From: [REDACTED]
Sent: Monday, 29 February 2016 6:02 PM
To: Corporate Email
Subject: Objection to Casuarina Town Centre, MP 06_0258 MOD 10, Mixed Use Subdivision

Re: Casuarina Town Centre, MP 06_0258 MOD 10, Mixed Use Subdivision

**Casuarina Town Centre Master Plan – Major Project: MP06_0258 MOD10,
Mixed Use Subdivision**

FIGURE No. DA44D (21/12/09)
PROPOSED CYCLEWAY/DRAINAGE
RE-ALIGNMENT LAYOUT PLAN

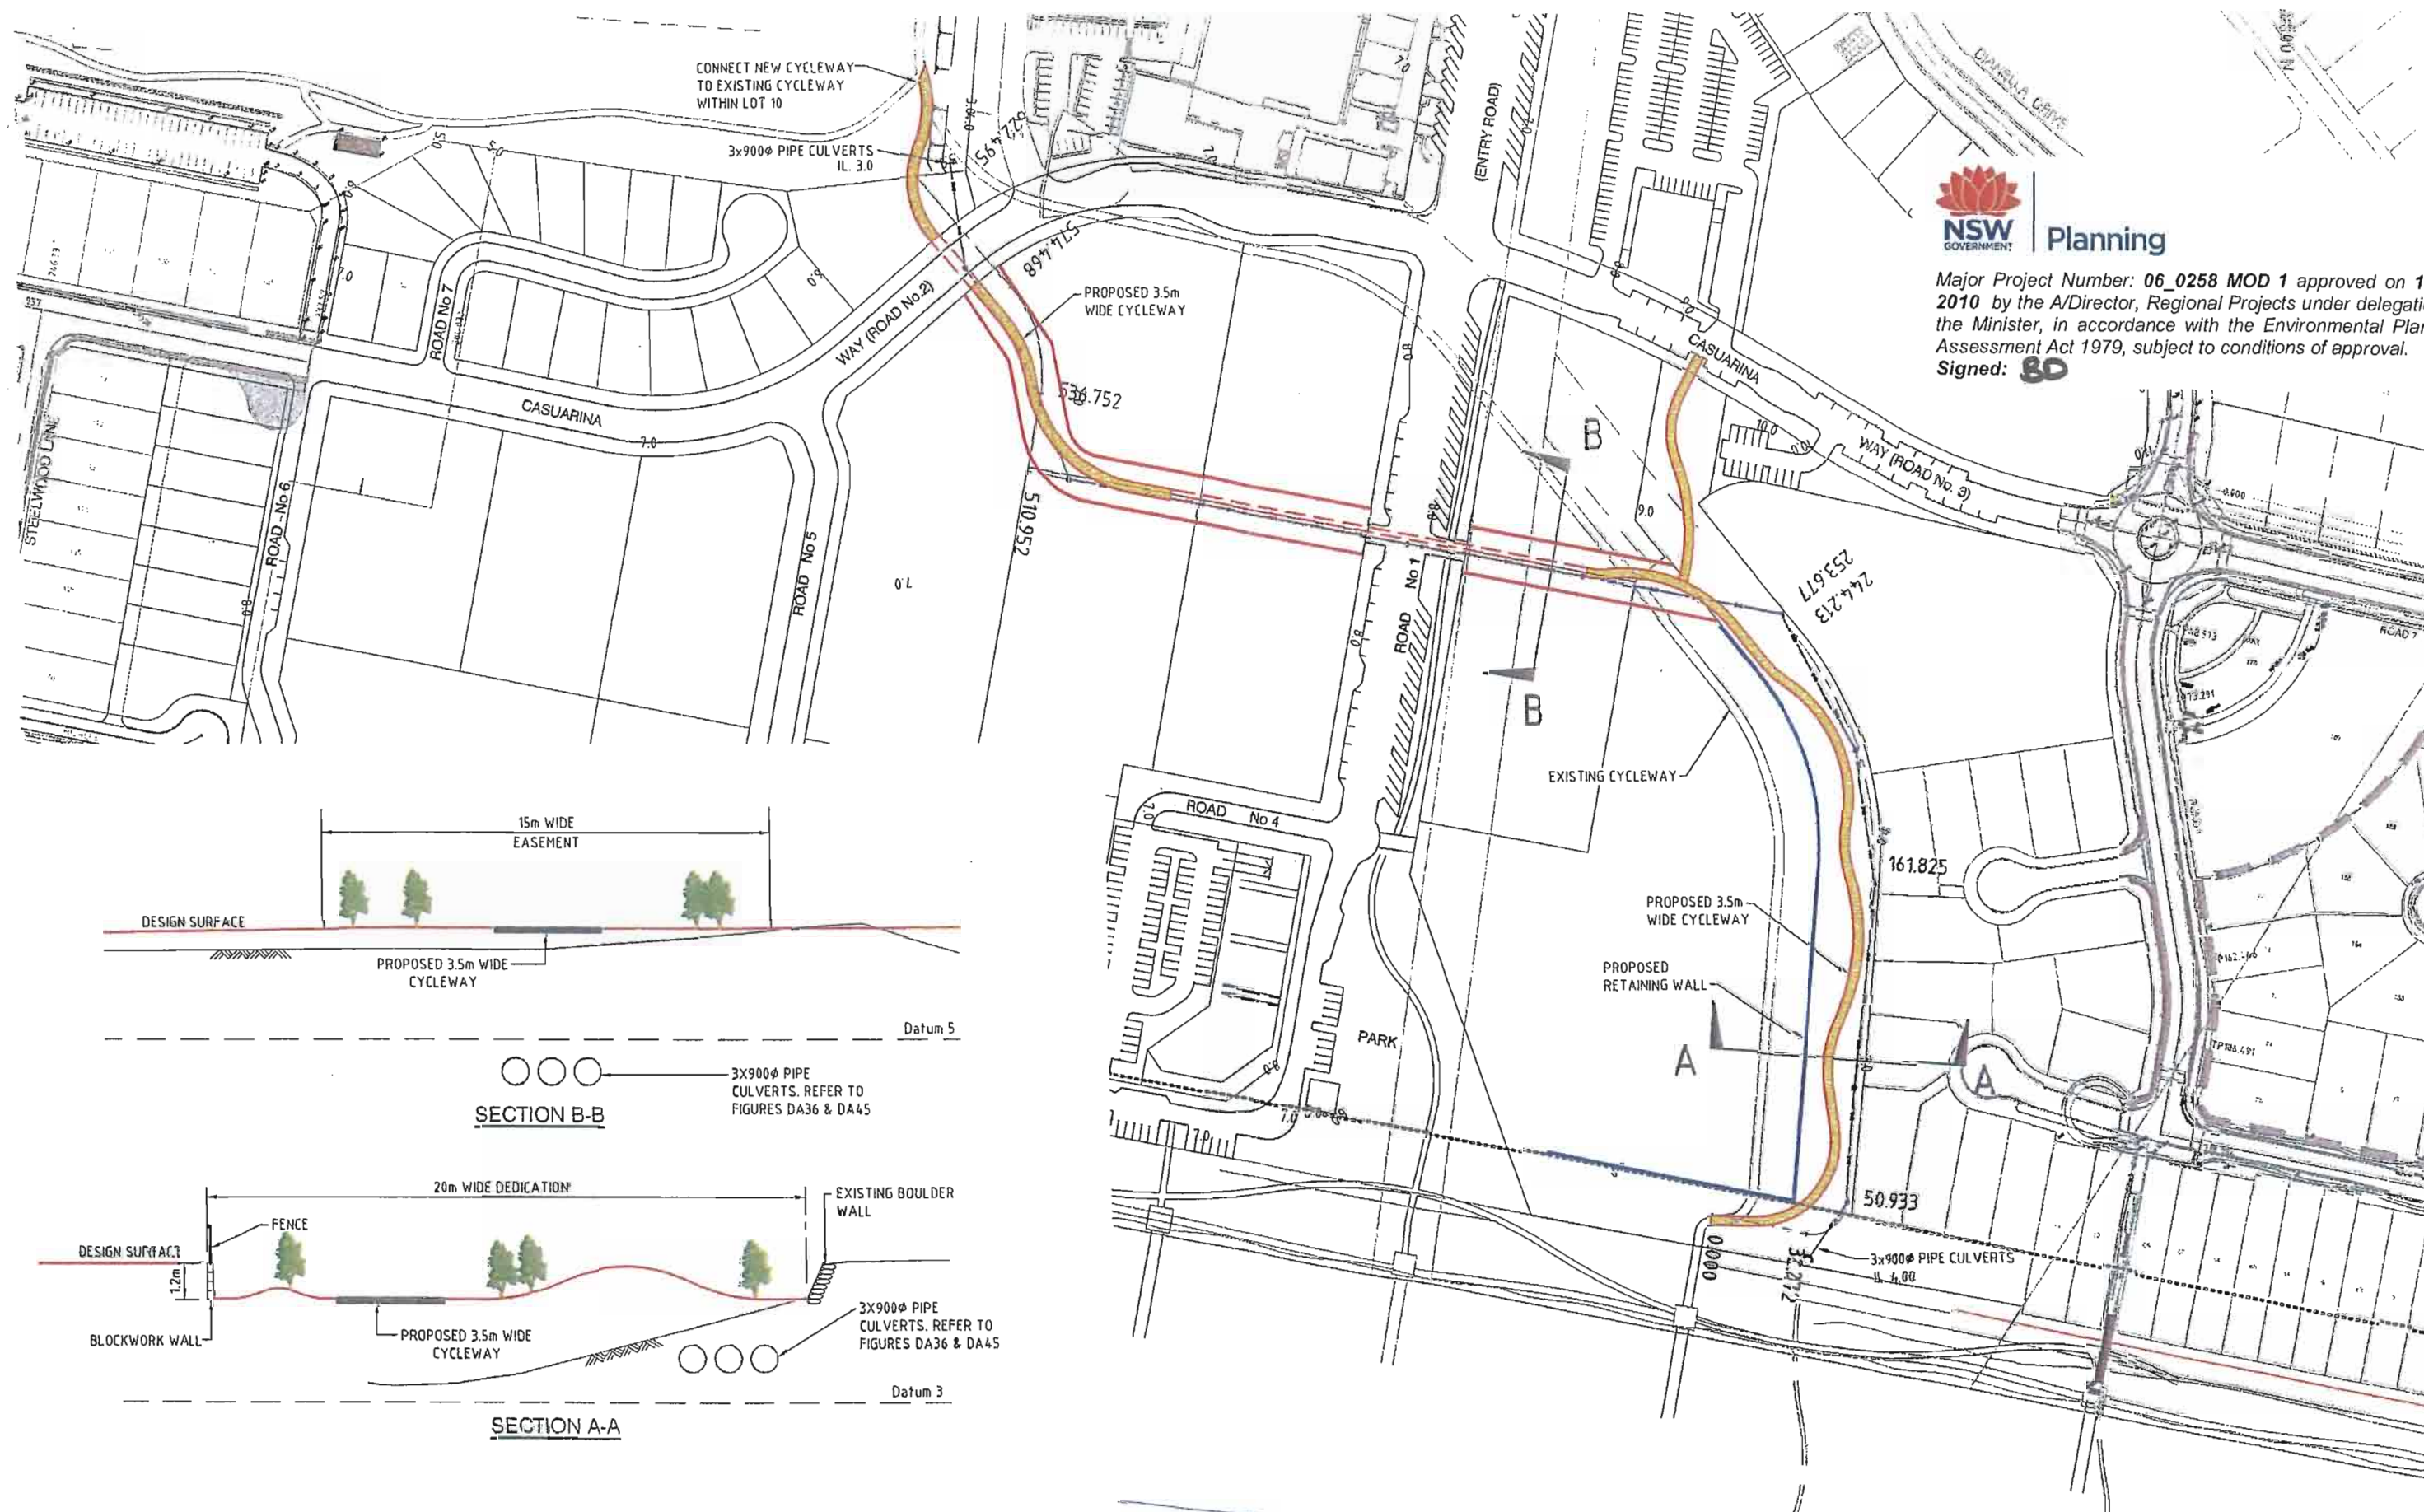
a. pages 2 and 3 detail the approved drawings which include drawings DA26L and DA44D. Both of these drawings detail the 20m wide dedicated

a. pages 2 and 3 detail the approved drawings which include drawings DA26L and DA44D. Both of these drawings detail the 20m wide dedicated
